**Planning Department
Transportation Development Services**

November 24, 2014

**Re: Office/Warehouse, 8620 President Place
Traffic Circulation Layout**
Architect's Stamp dated 11-19-14 (C17-D122)

date
11-19-14
sheet
C100

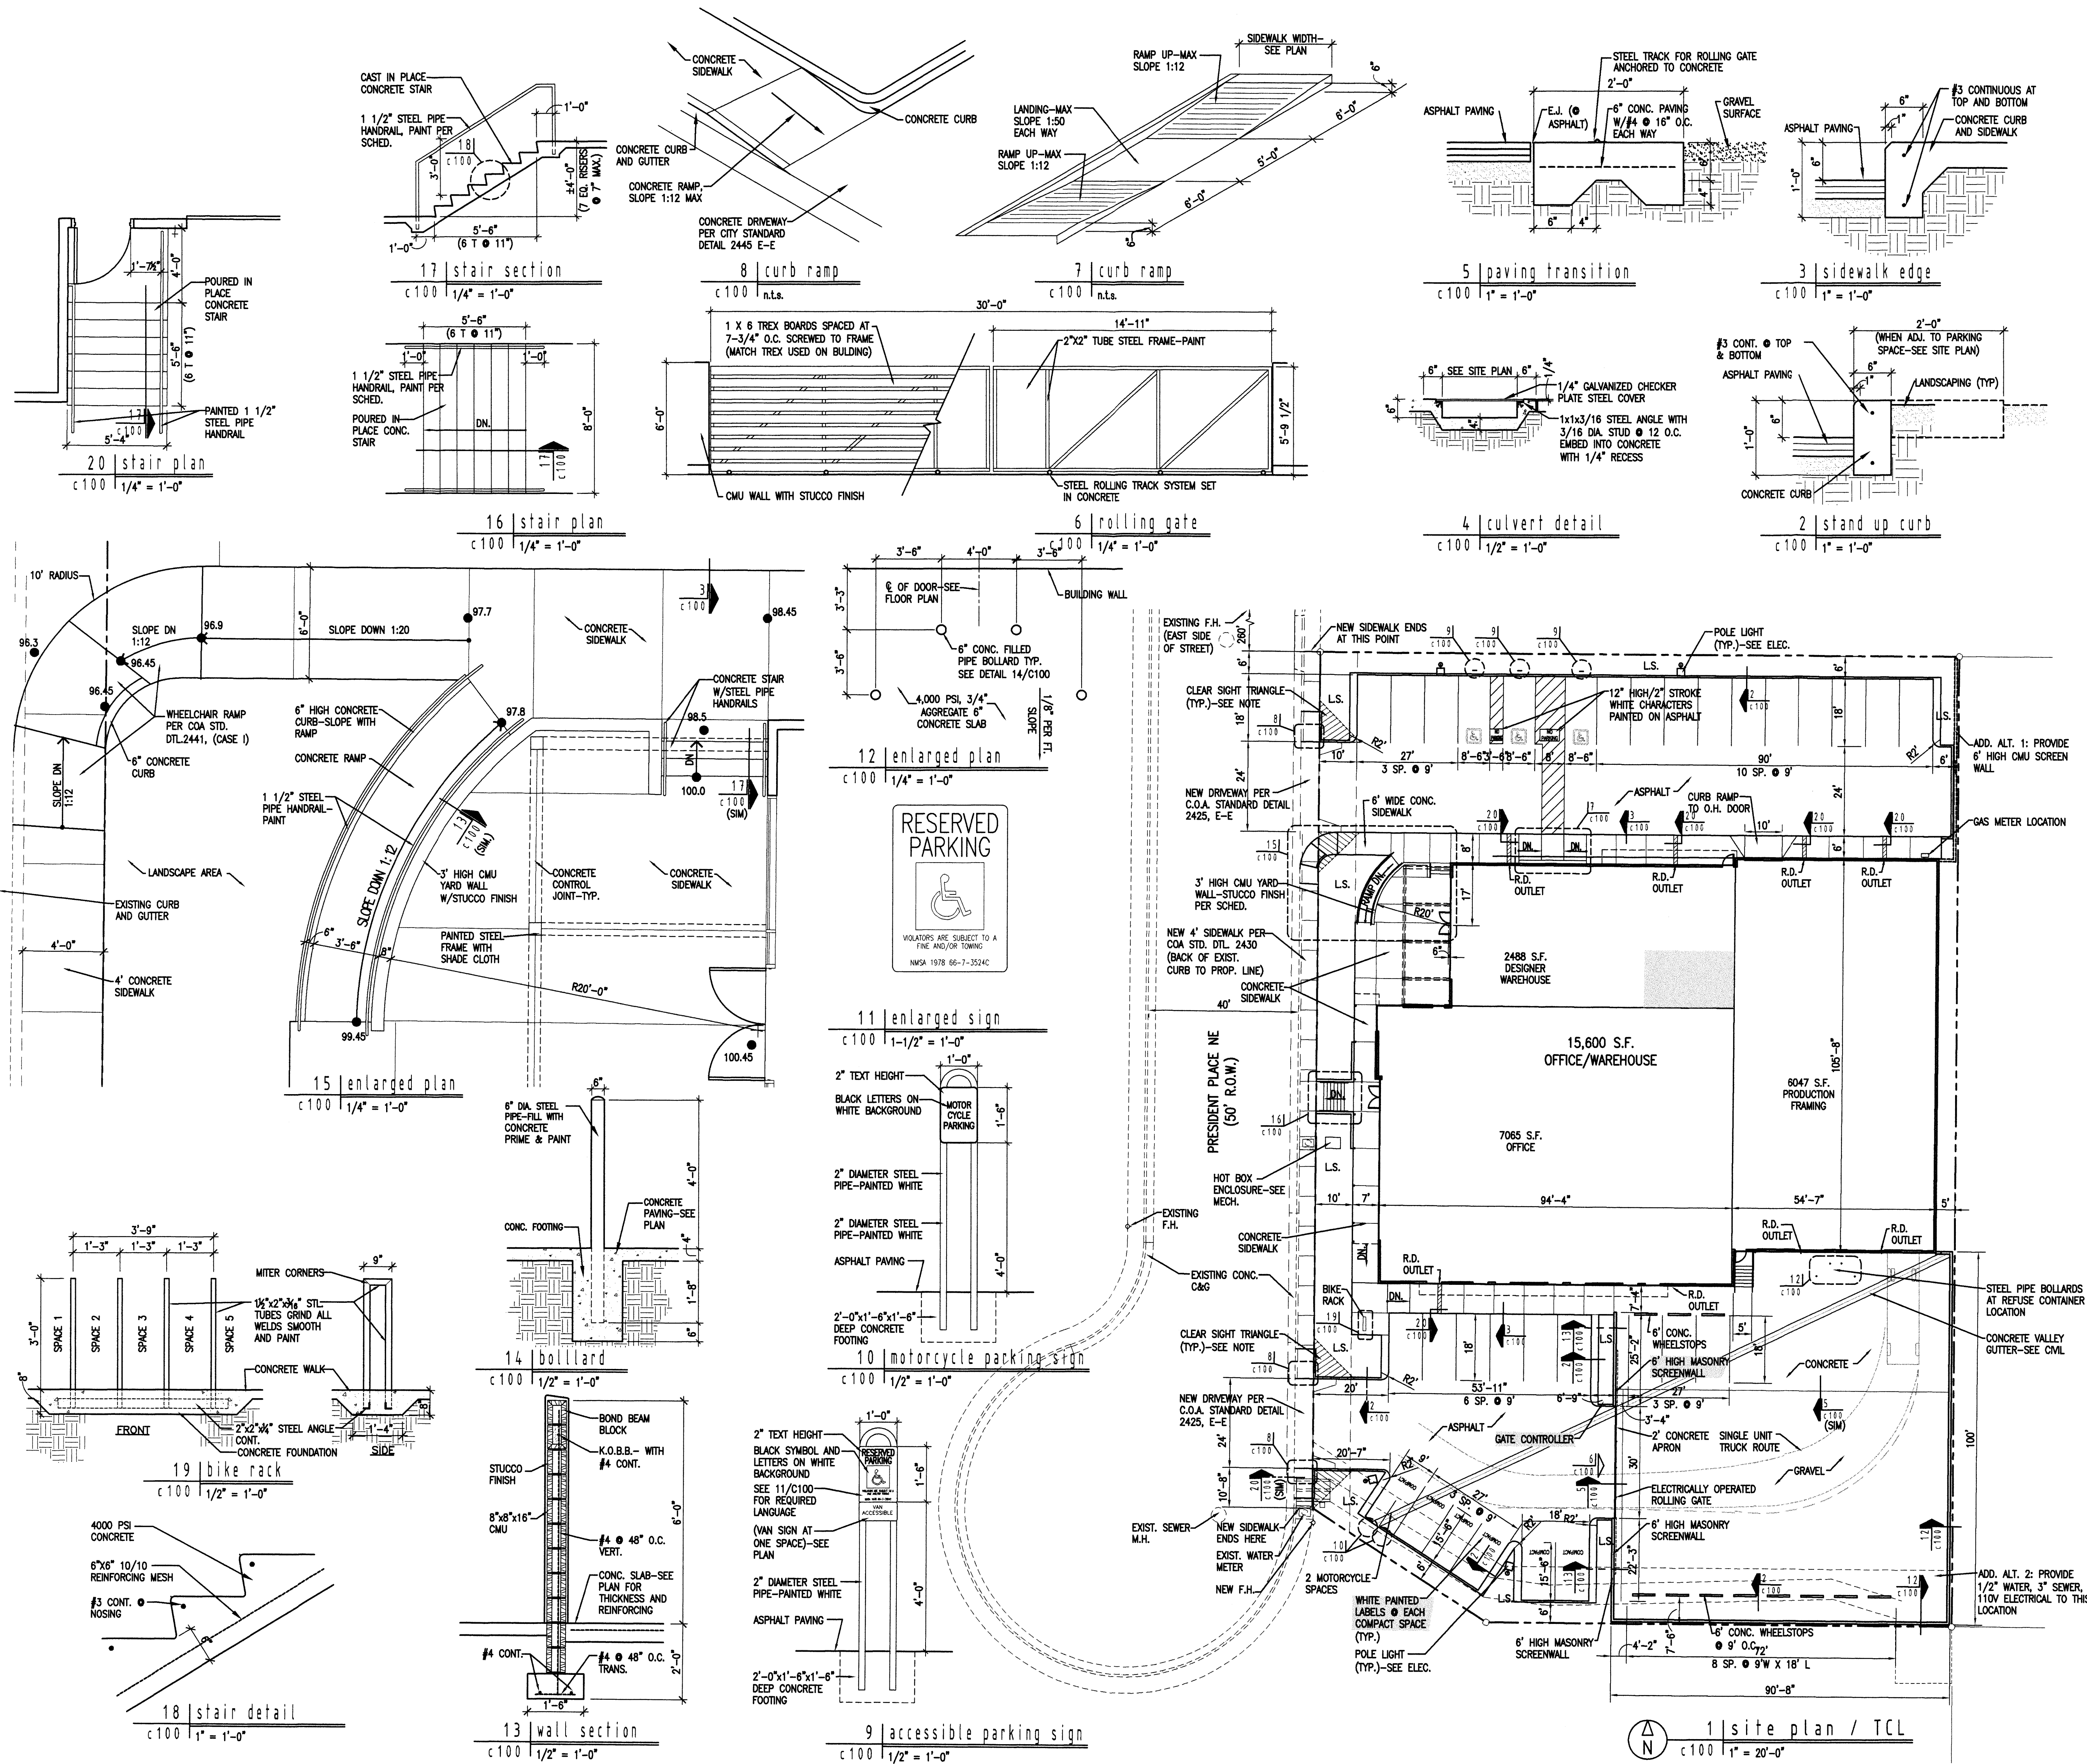
1. Please provide a zone atlas number for the vicinity map.
2. Per the DPM, a 6 ft. wide ADA accessible pedestrian pathway is required from both President Place and the parking lot to the building entrances. Detail 15 shows a ramp that is only 3'-6" wide, and it needs to be widened to 6 feet.
3. Detail 15 conflicts with the construction of a drivepad. If you are building a drivepad, no wheelchair ramp is needed.
